From: Jeff Thomas <jeff.thomas@mercerisland.gov>
Sent time: 2022/06/16 09:36:26 PM
To: Kate Miller <kate@brandtdesigninc.com>
Cc: Colin Brandt; Bree Medley <bree@brandtdesigninc.com>; Andrew Leon
Subject: RE: Building Permit No. 2109-150
Attachments: FW: Building face /height question RE: Permit # 2109-150 Clarifications 220510_2109-150_HeightCoordinationPackage.pdf

This message is responsive to your request for clarification related to Building Permit No. 2109-150, specifically the application of Mercer Island Municipal Code (MICC) 19.02.020(E)(2) for maximum building height on downhill building façade. We discussed the matter at issue during a video meeting on May 26, 2022. MICC 19.02.020(E)(2) requires maximum building height on downhill building façade as follows:

BUILDING ELEVATIONS

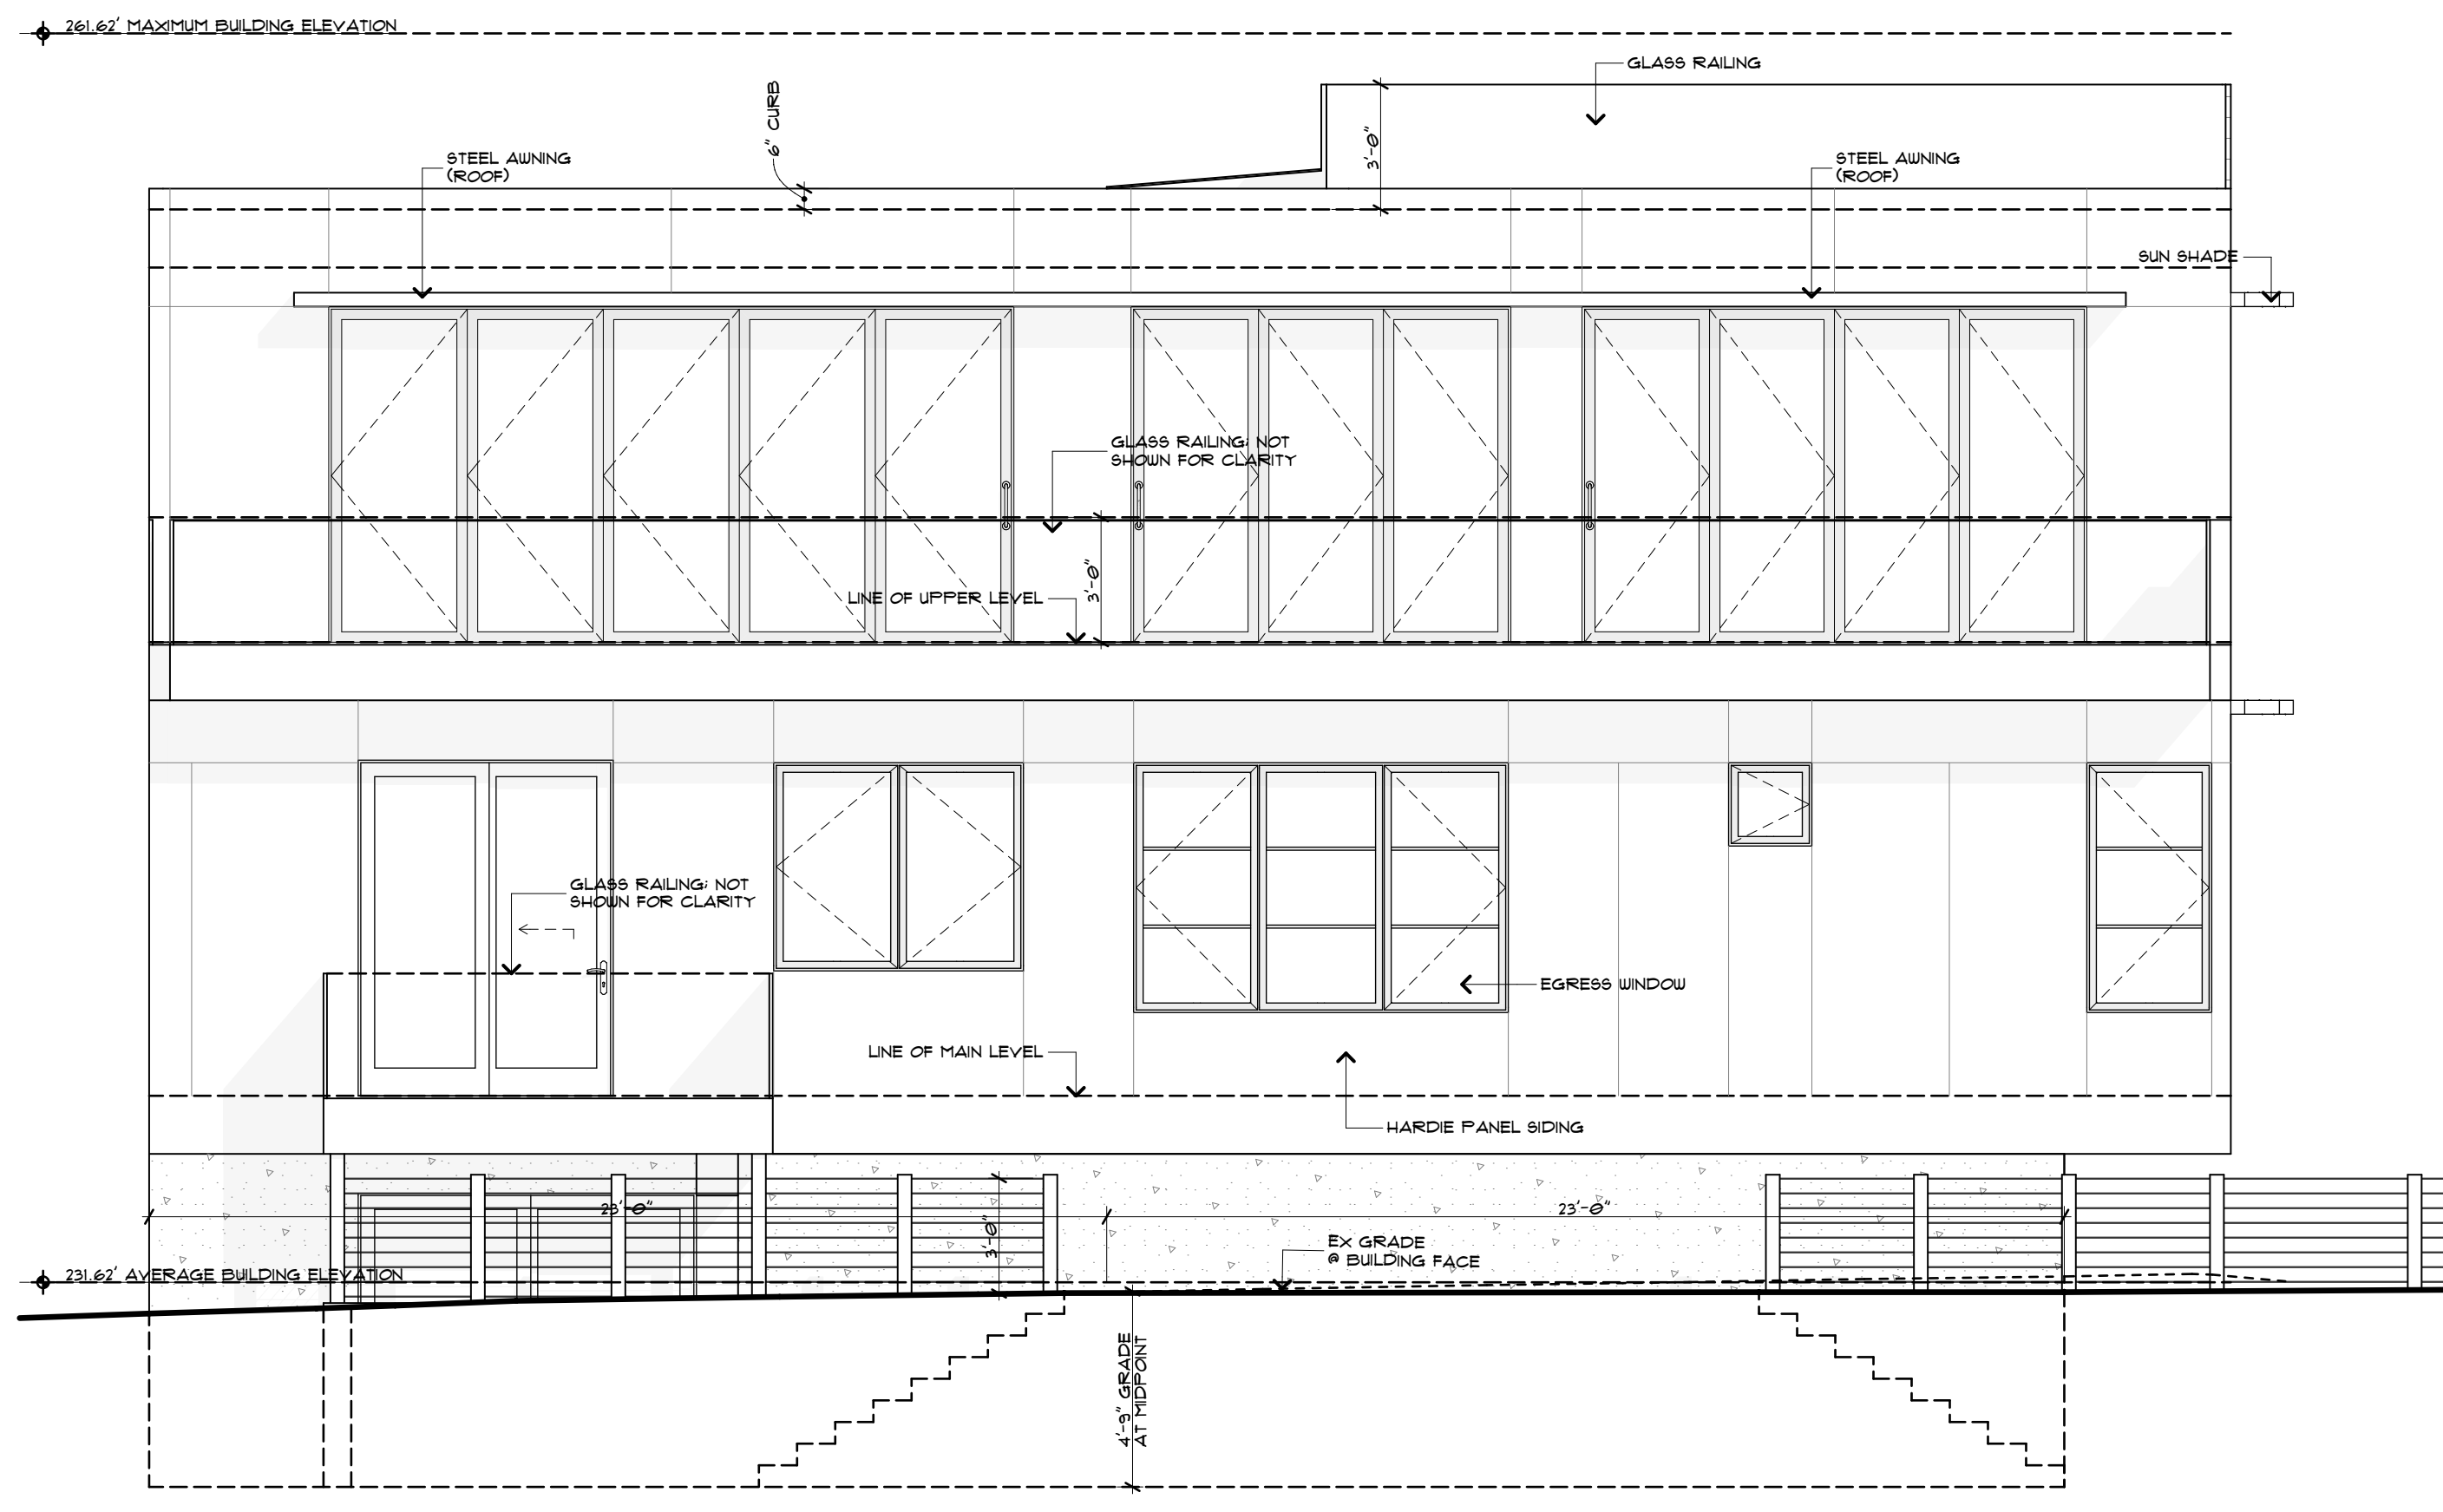
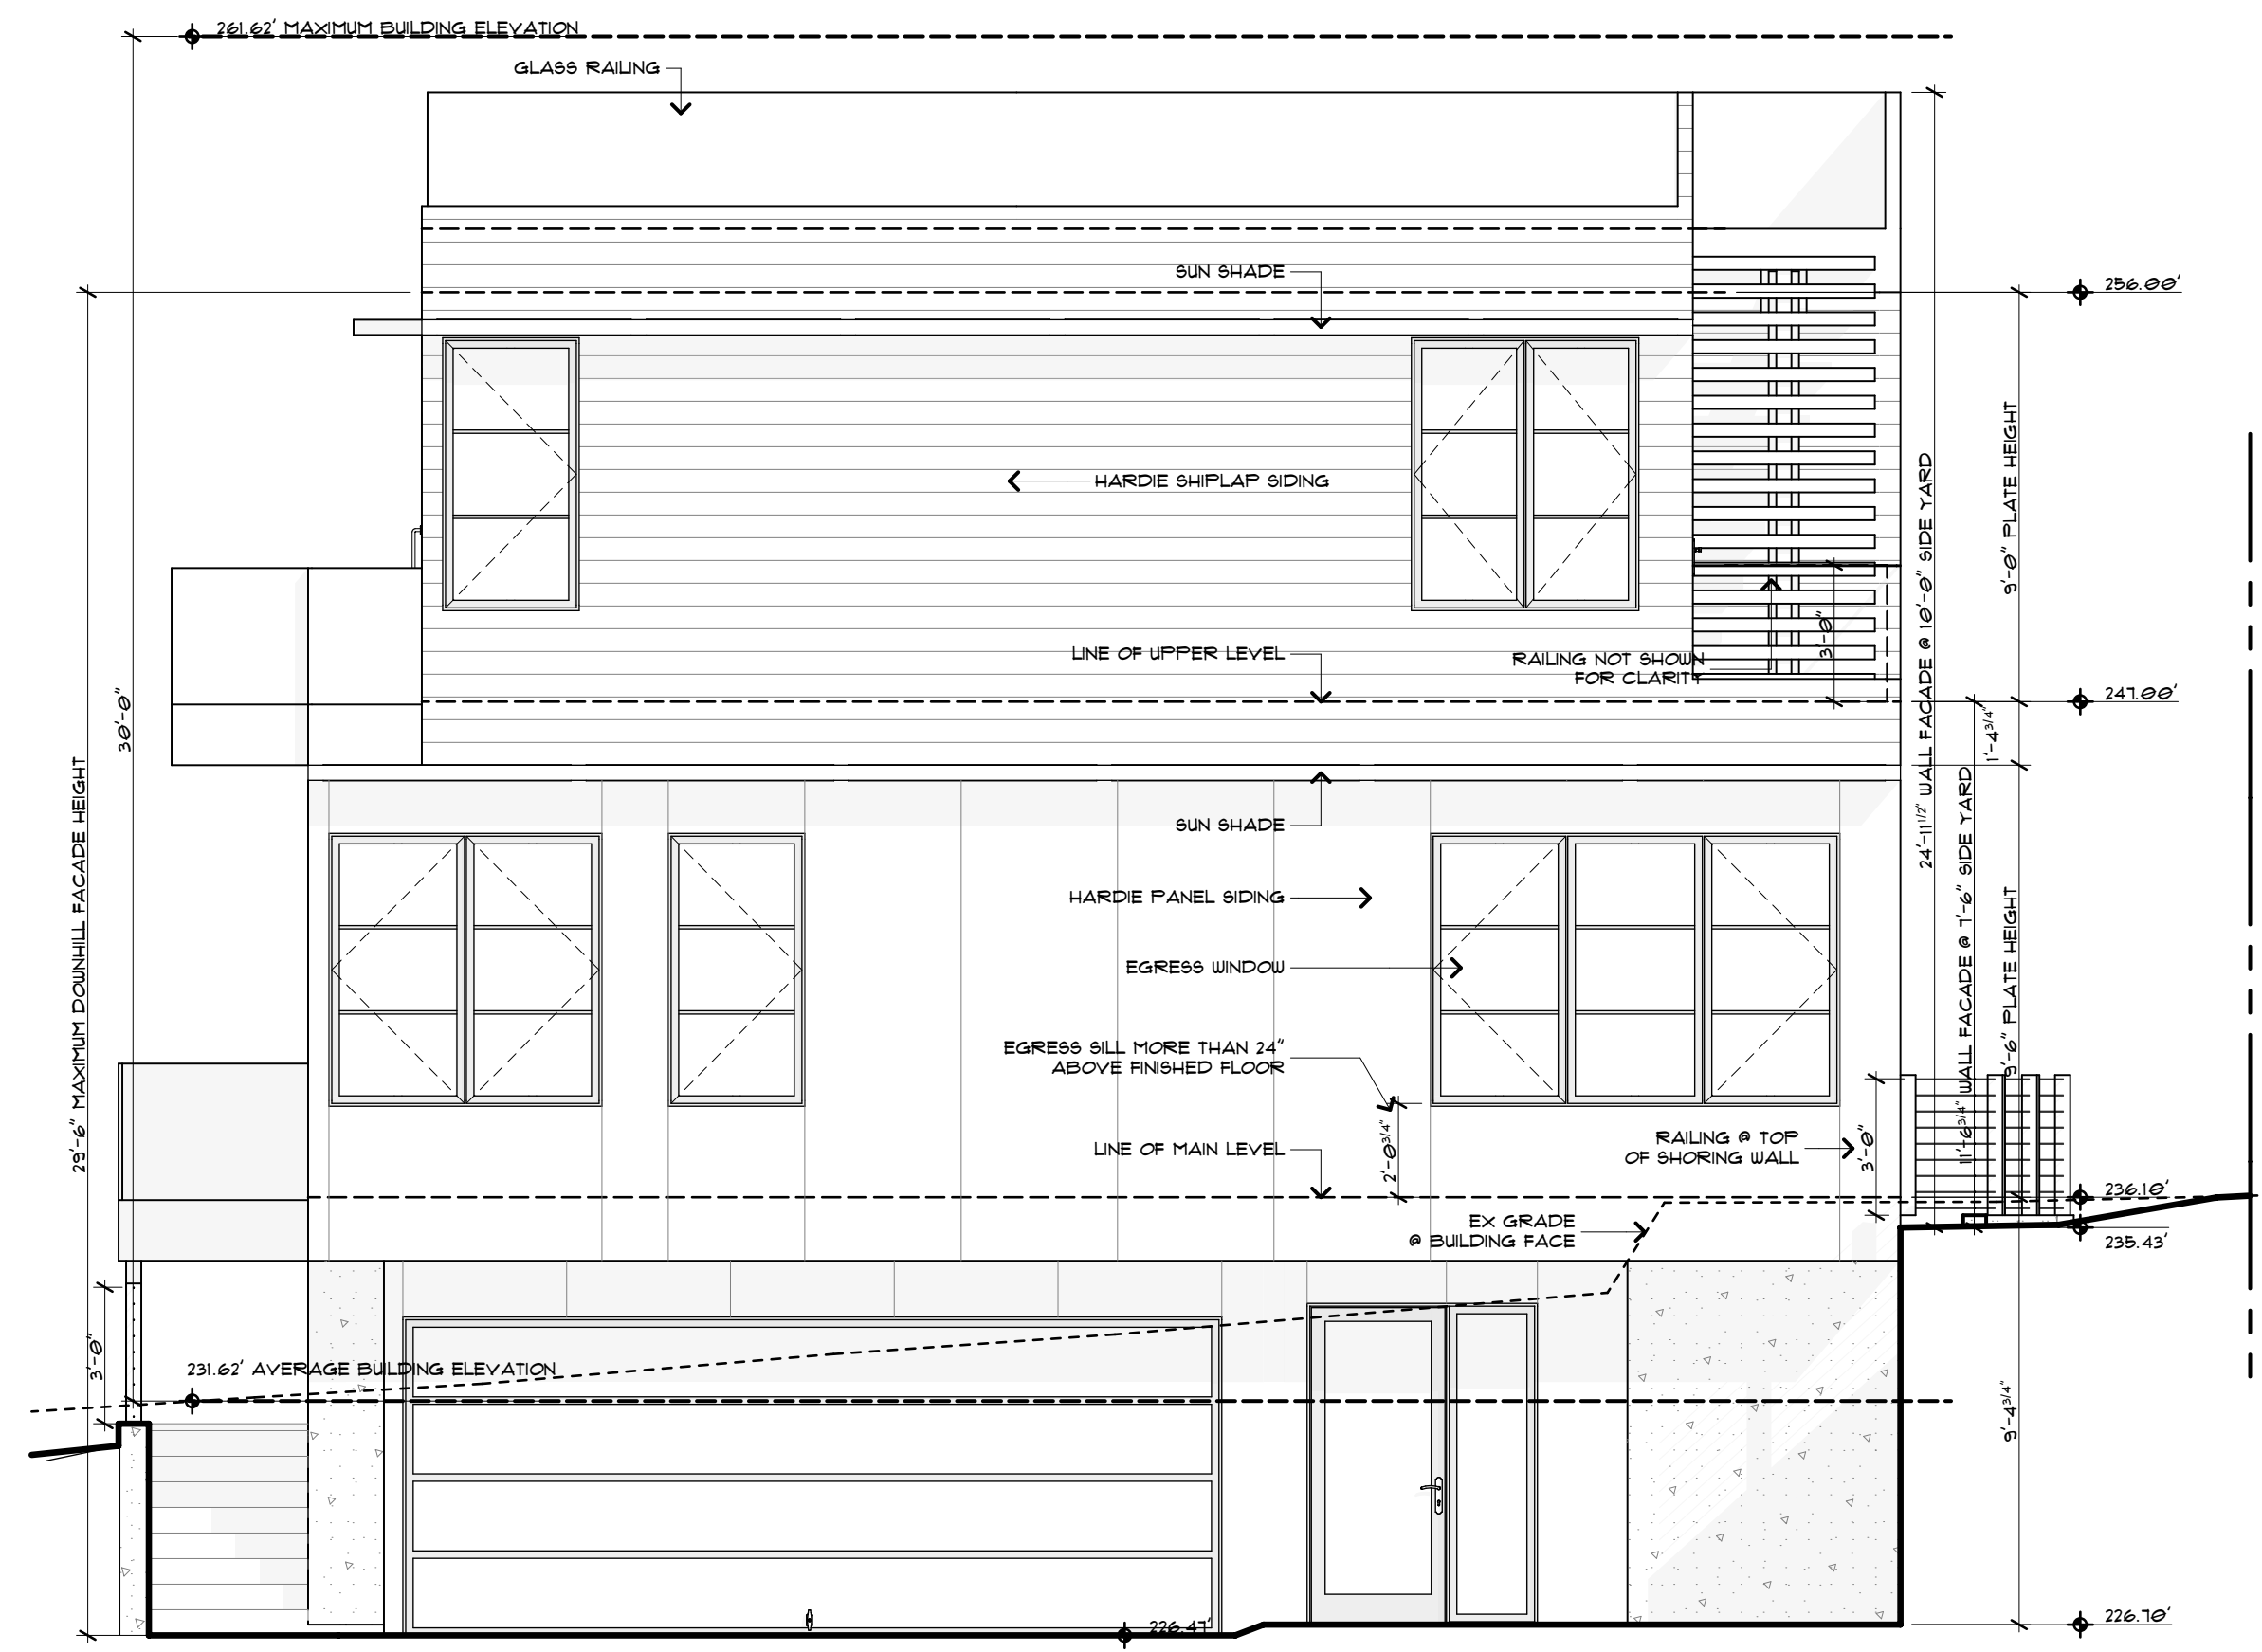
2. The application of MICC 19.02.020(E)(2) to the proposal contained within Building Permit No. 2109-150 results in a building height on the downhill building façade of 33-feet, 6-inches (see attached).

3. MICC 19.02.020(E)(2) does not contemplate multiple building facades or exterior wall facades on the downhill side of a sloping lot – only the maximum building façade height as a singular treatment, the exterior wall façade supporting the roof framing, rafters, trusses etc.

6. Therefore, in the absence of further direction in the MICC, there are two options to resolve the building height on the downhill building façade of 33-feet, 6-inches for Building Permit No. 2109-150:

- A. Revise this application to comply with MICC 19.02.020(E)(2) 30-foot requirement; or
 - B. Apply for a Zoning Variance to seek relief from this requirement.
